**TRI-LAKES MONUMENT FIRE PROTECTION DISTRICT**

July 10, 2019

File Number: PPR1919

Applicant: Steel Structures America

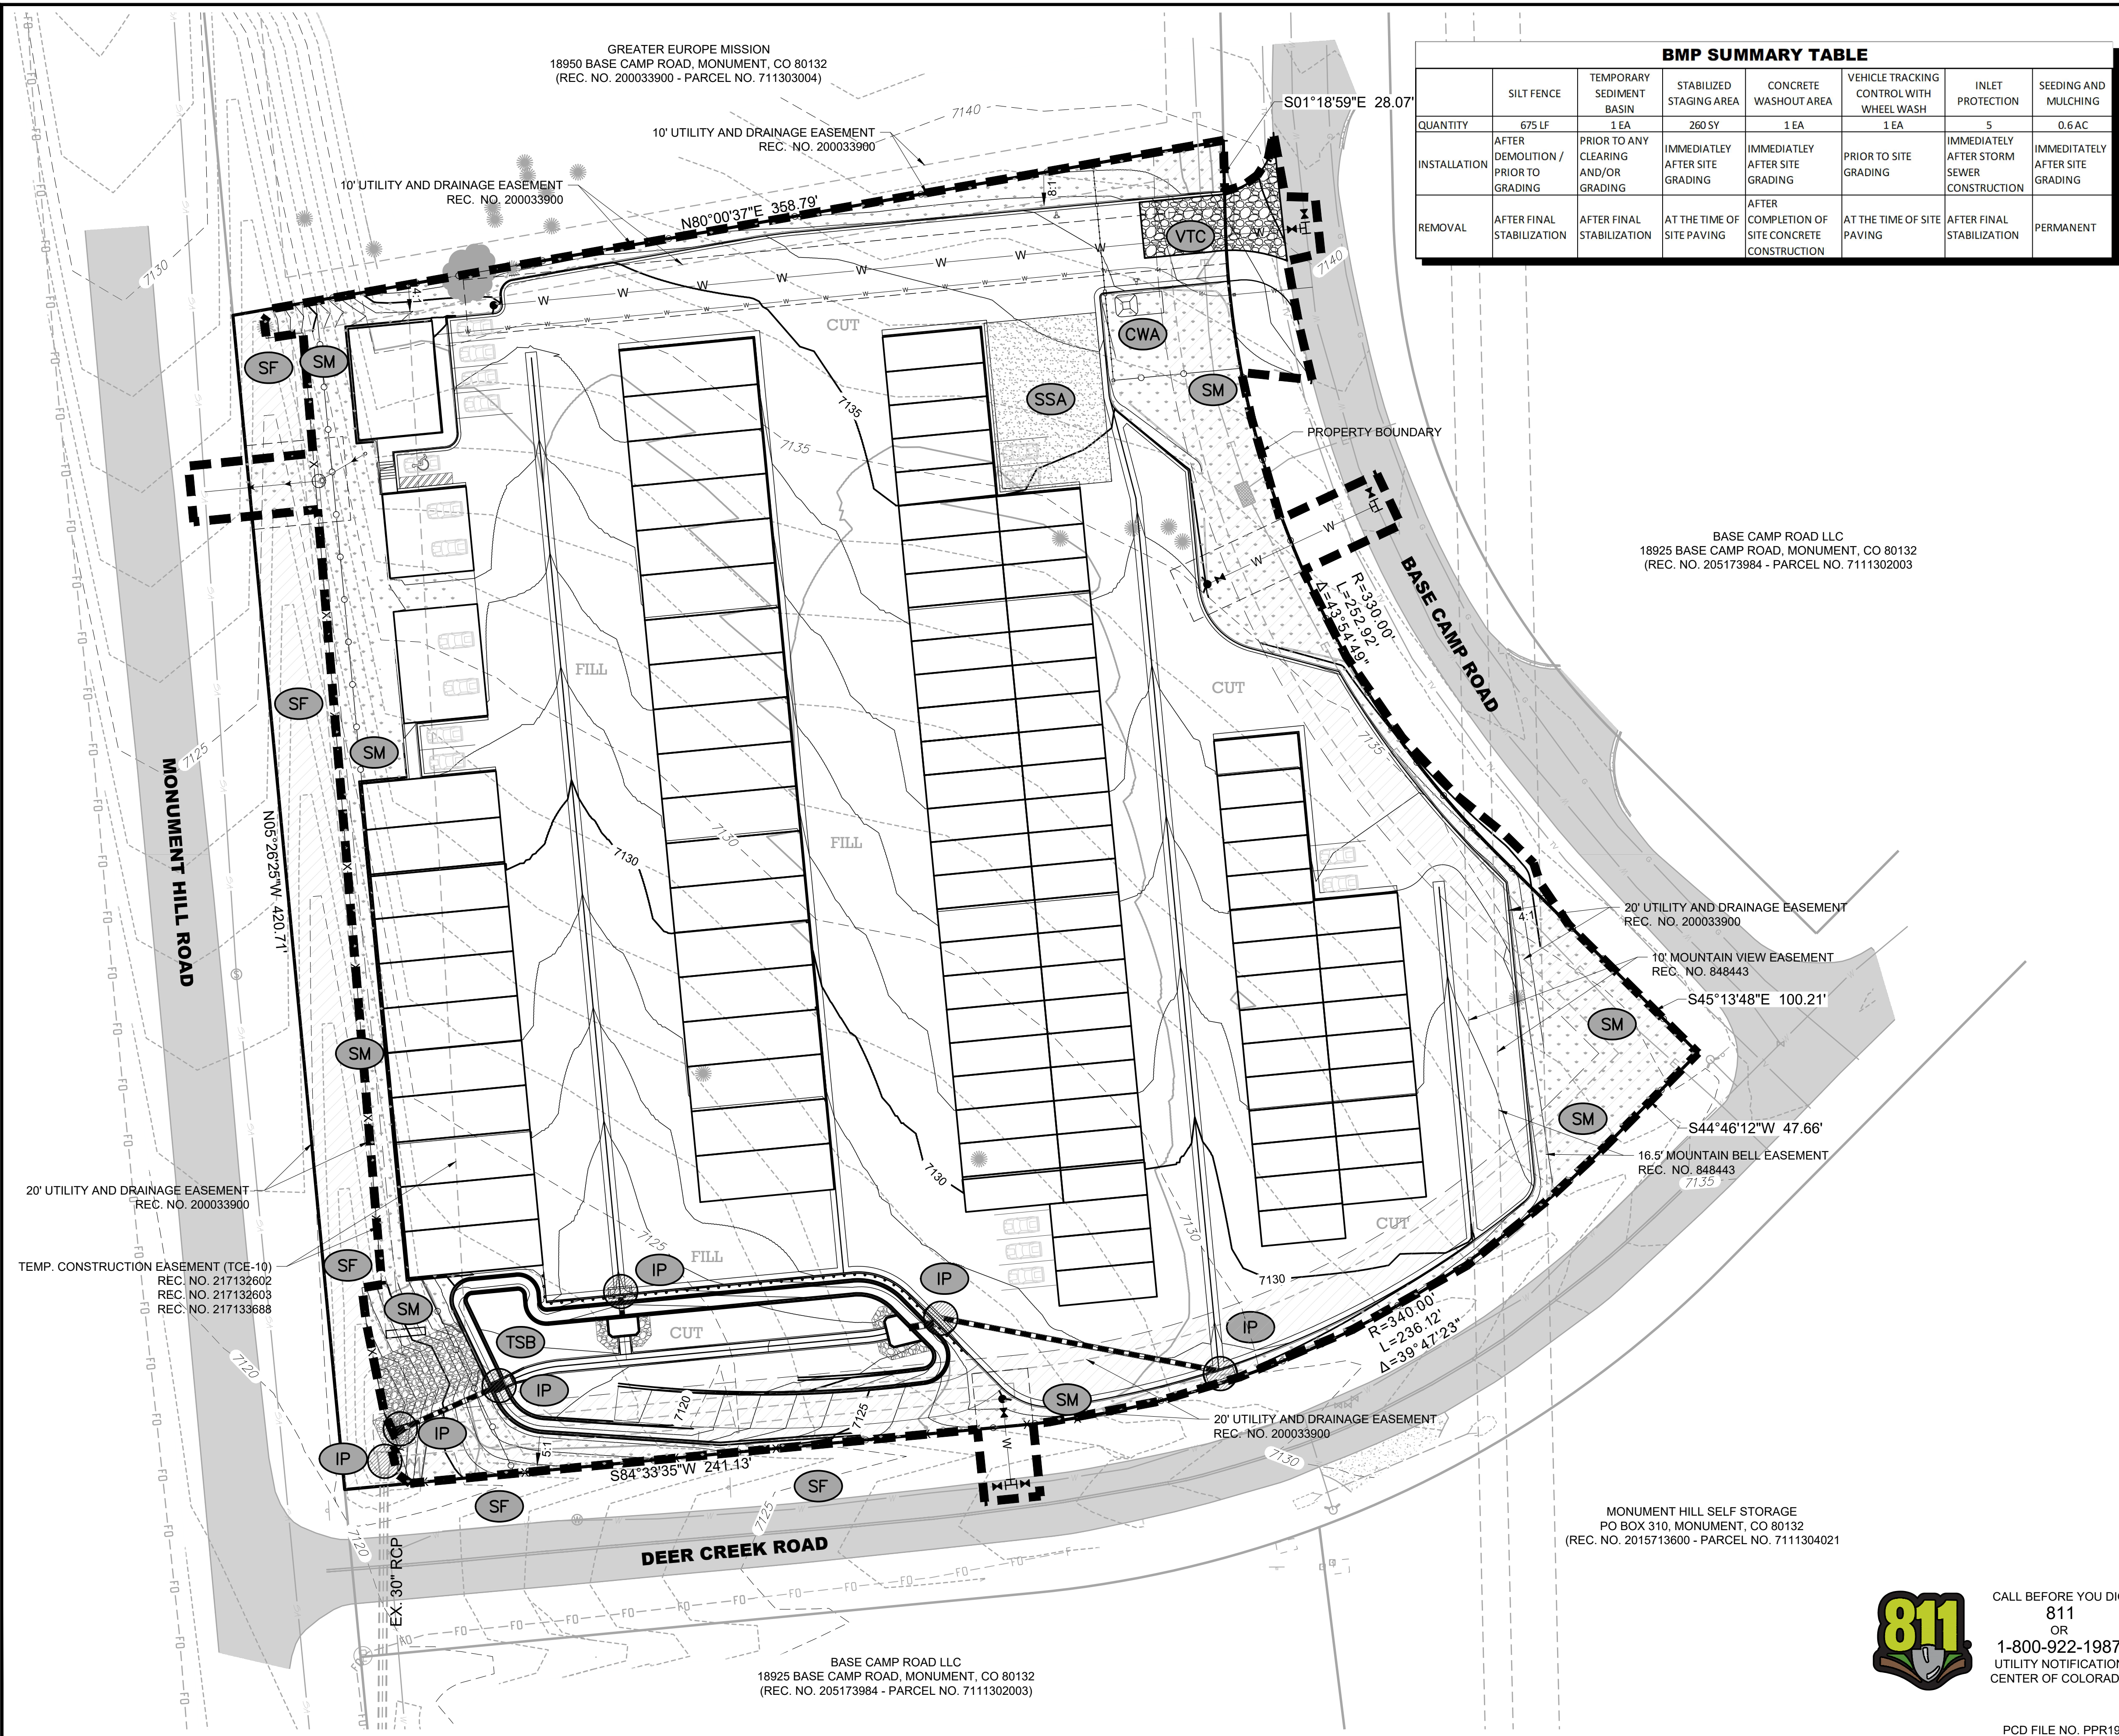
1. The number of hydrants seems low and will most likely need additional fire hydrants when we reach the building design and approval phase. Particularly due to these type occupancies normally having fencing which limits access to other fire hydrants outside of the property.
2. Site access plans will need to include fire department templates for aerial apparatus due to the nature of the storage units as proposed.
